Appendix J: Visual Impact Peer Review

Rye Park Wind Farm Modification 1 Peer Review of VIA

09 March 2020

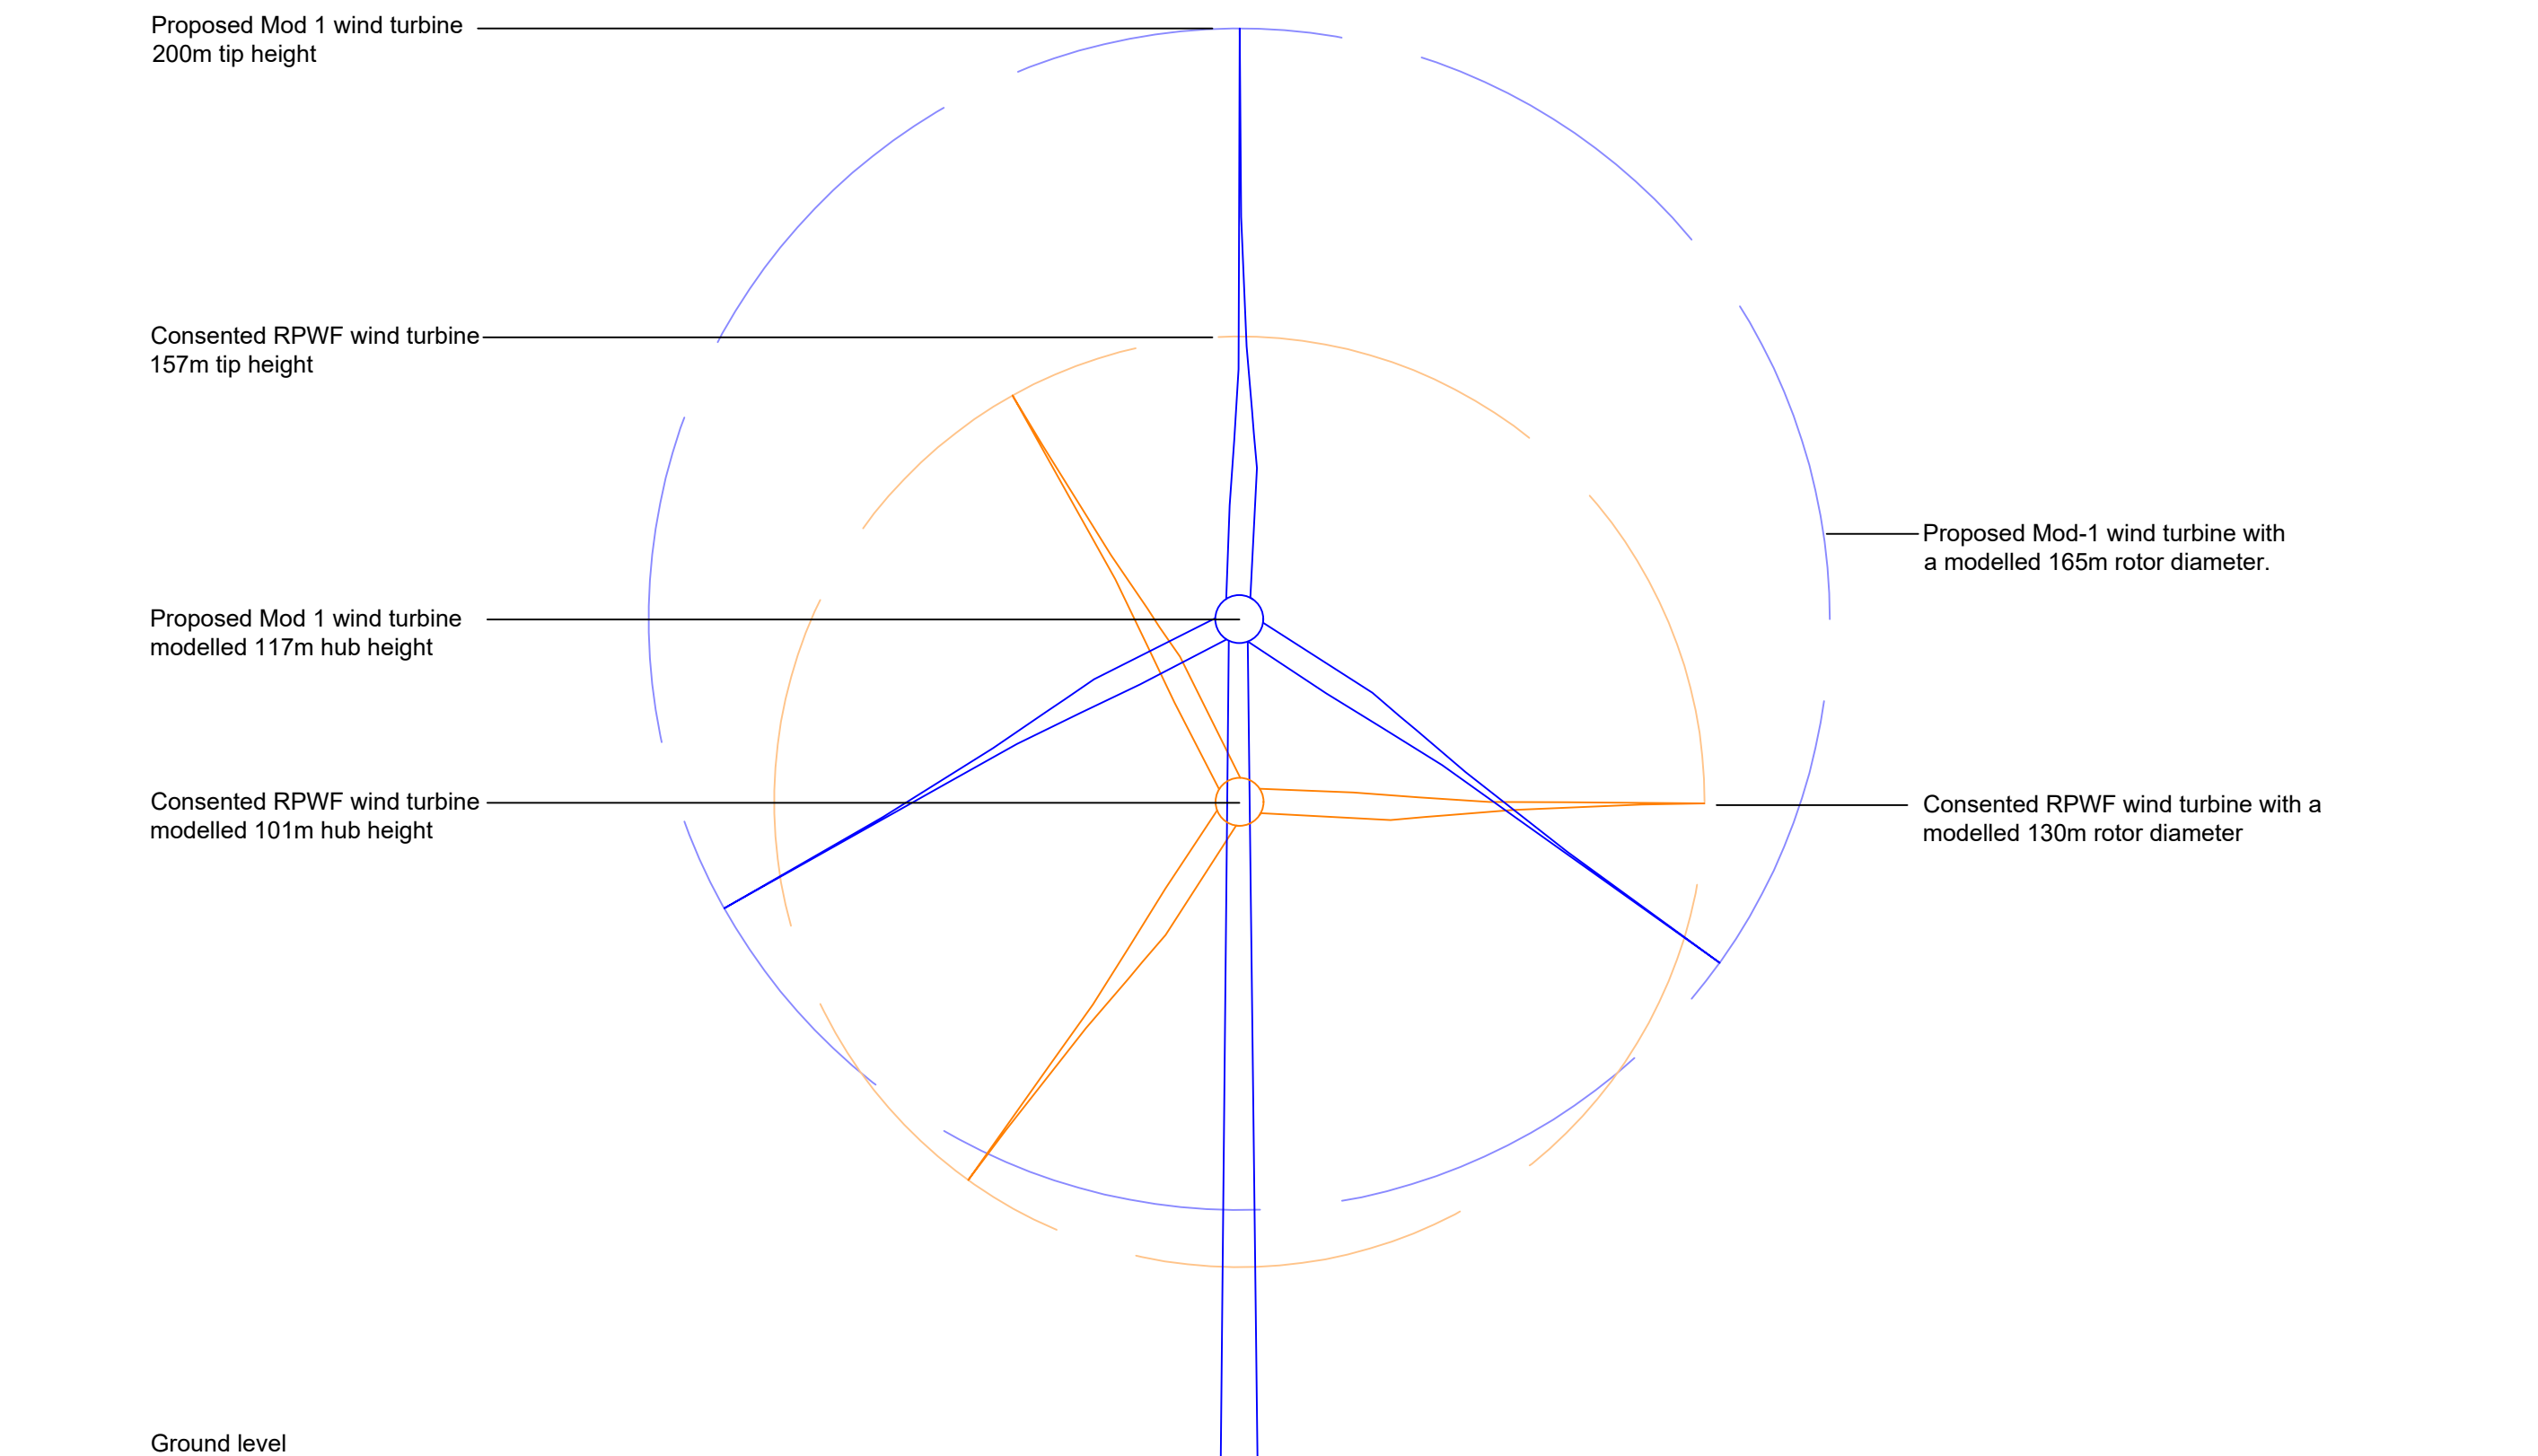
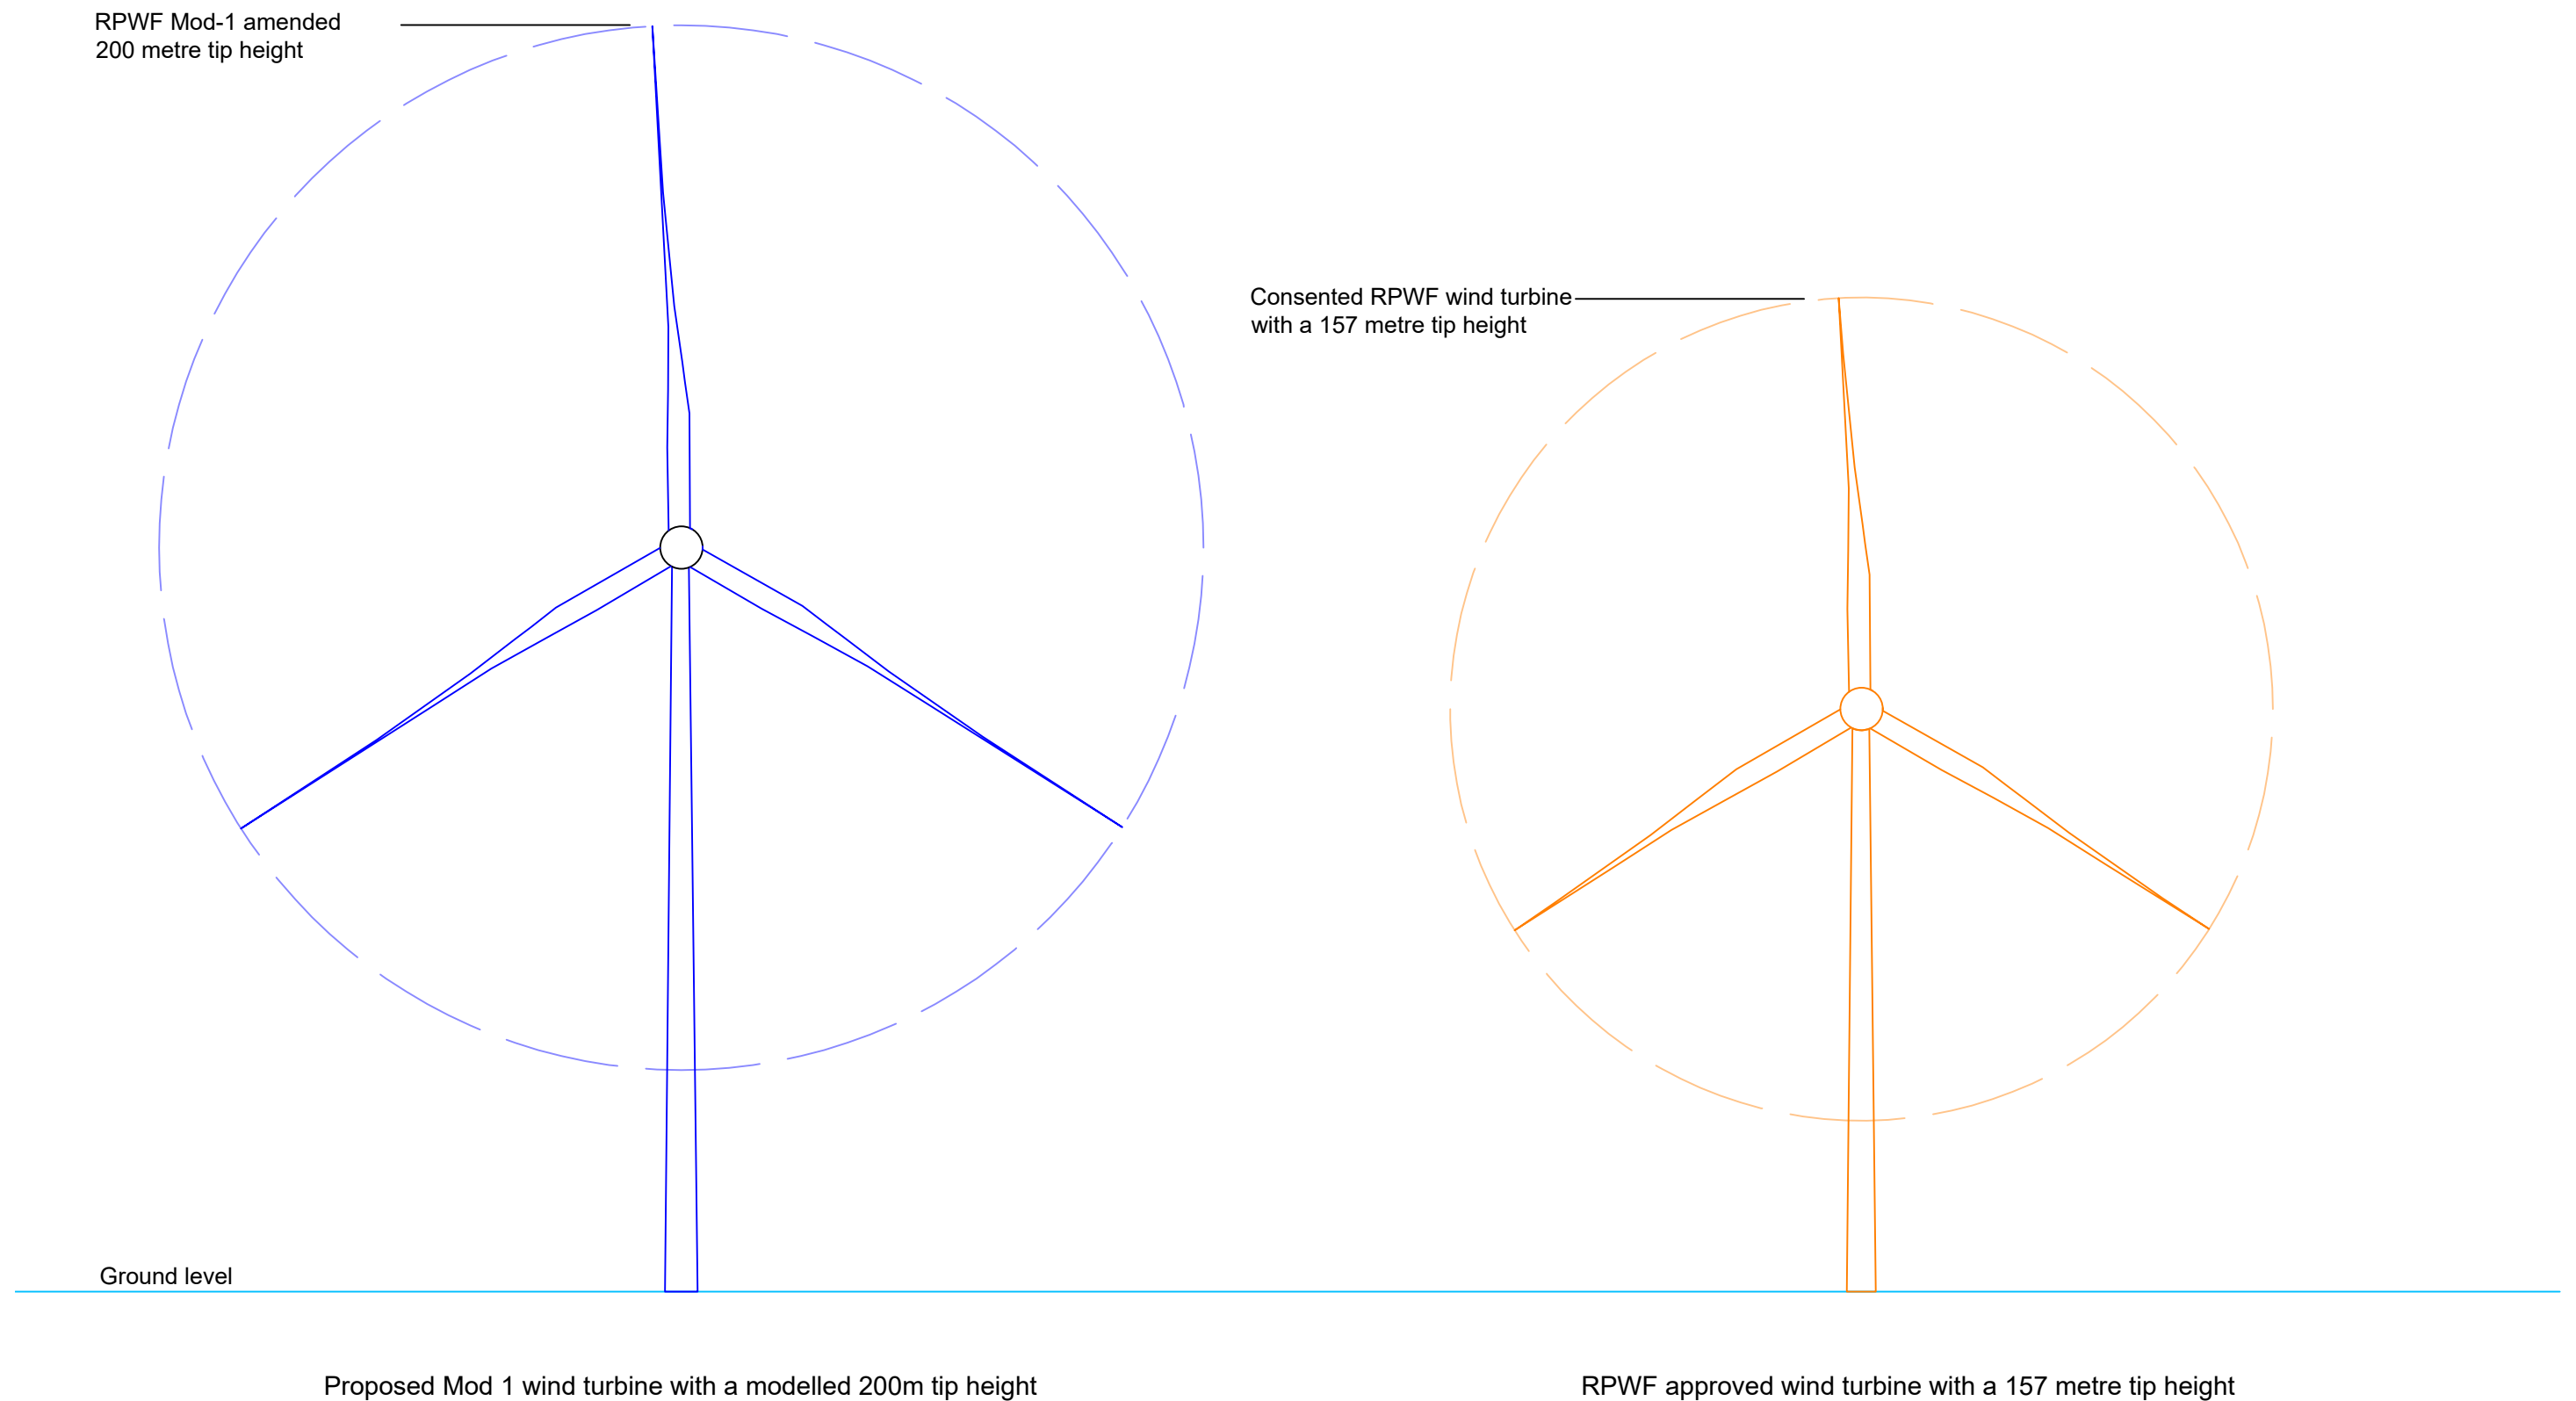
12. The VIA demonstrates graphically, through scale and the visual magnitude at distance, the comparison between the approved and Mod 1 turbines which informs the conclusions of effect on each receiver in Table 5. The magnitude assessment is undertaken at distances of 2.7km and 4km which is reference to Figure 5. Visual Magnitude Thresholds for Visual Assessment in The Bulletin.
